COMMUNITY SERVICES DEPARTMENT

July 30, 2020

Subject: Abeyta Minor Subdivision (MS203)

SEDONA SUN ACRES FILING NO. 1

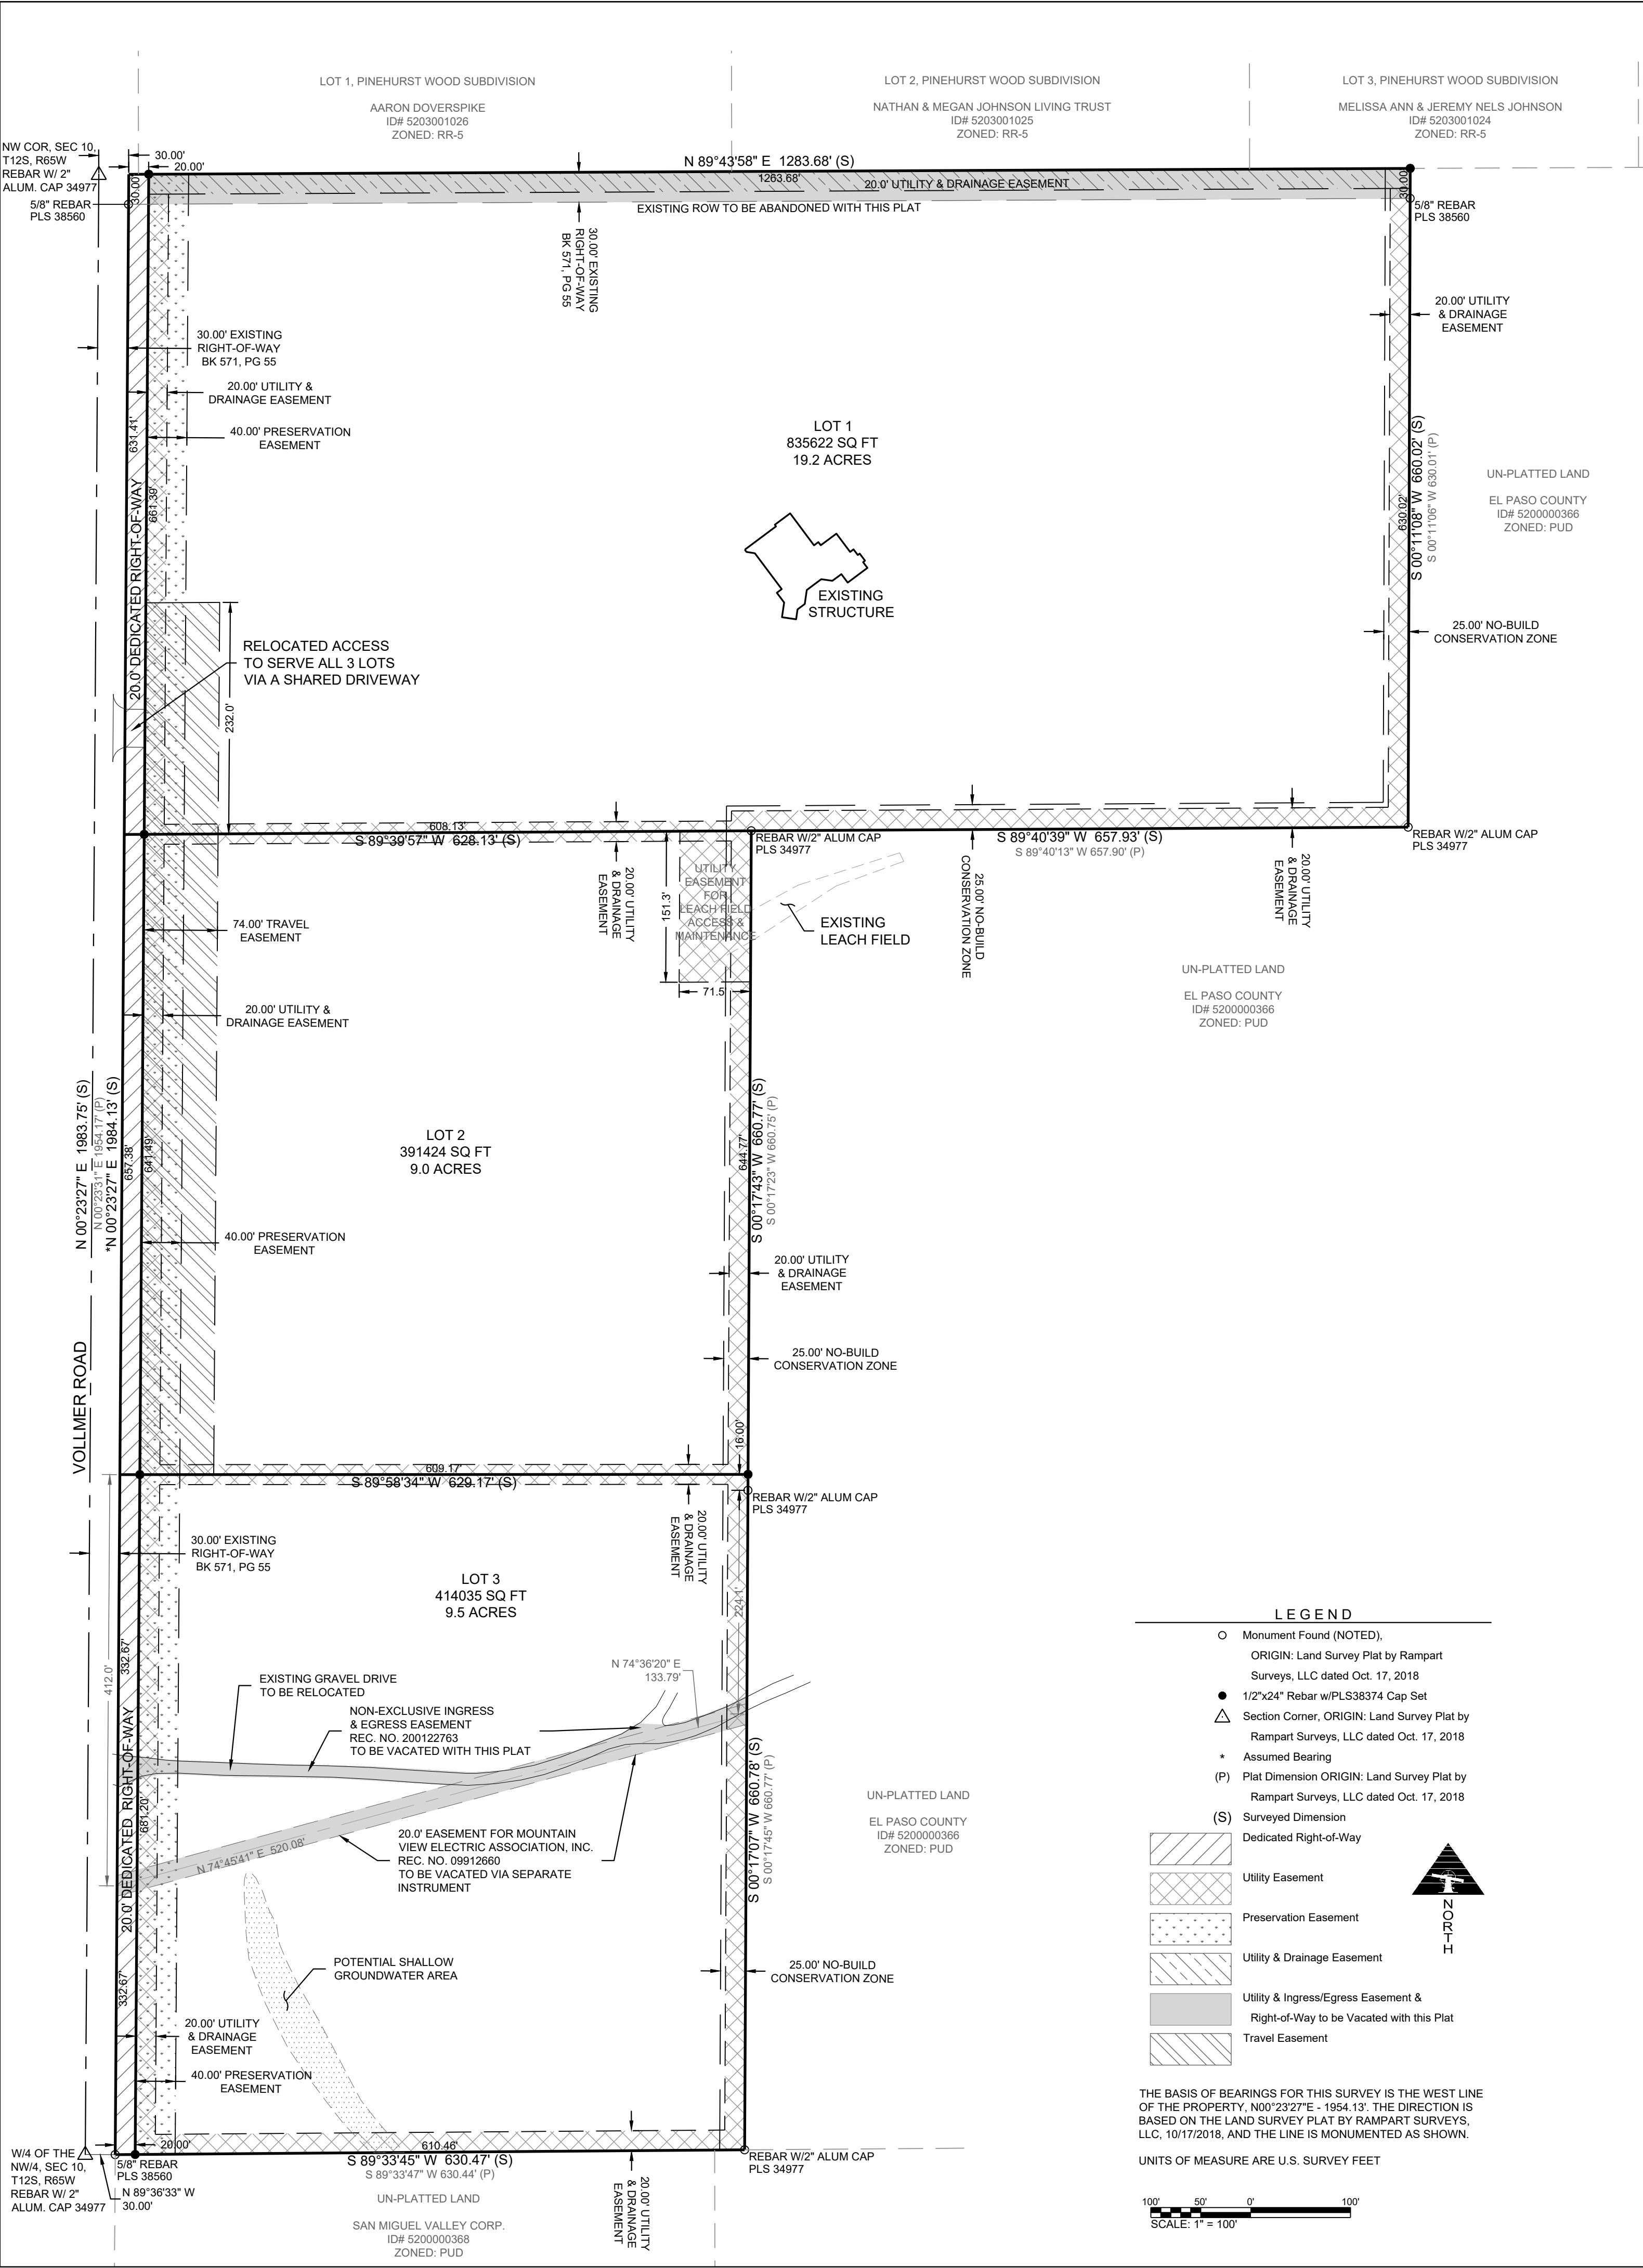
The El Paso County Parks Master Plan (2013) shows a proposed bicycle route along Vollmer road which is impacted by the minor subdivision. This bicycle route will be accommodated within the public right-of-way which is being shown on the plat drawing as a 40' preservation easement. No easement requests are necessary; however, the applicant is advised that multi-modal transportation options will be developed with the right-of-way in the future.

The Pinerias Open Space is located directly adjacent to the east of this subdivision. The open space is managed in conjunction with the Palmer Land Trust through a conservation easement which seeks to protect the scenic, wildlife, aesthetic, recreational, and ecological conservation values in perpetuity. Staff is concerned about the proximity of residential development to the open space and the potential impact to the conservation values El Paso County is charged to protect. This includes impacts from stormwater runoff, encroachment of noxious weeds, drifting of herbicides and pesticides, and trespass onto the property. Per LDC requirements the applicant is required to provide a 25-ft setback along each lot line to act as a buffer between residential and nonresidential properties. Staff would ask that the applicant instead provide a 25-ft no-build conservation zone along the lot lines that border the open space to provide adequate protection to the open space.

There is an existing leach field located on the open space property that serves the existing residential house on Lot 1. El Paso County would ask the applicant to remove the leach field from the open space property and that this should be a condition of approval.

There is an existing right-of-way along the northern boundary of the minor subdivision. The Pineries Open Space Master Plan does not show any proposed public access along this corridor therefore it is not needed for the open space.

El Paso County Parks staff recommends that the Planning Commission and the Board of County Commissioners include the following conditions when considering and / or approving the Abeyta Minor Subdivision: (1) require fees in lieu of land dedication for regional park purposes in the amount of \$1,868 which will be required at the time of recording of the final plat, (2) require the applicant provide a 25-Ft no-build conservation zone along the lot lines bordering the Pineries Open Space, (3) remove the leach field located on the Pineries Open Space that serves Lot 1.
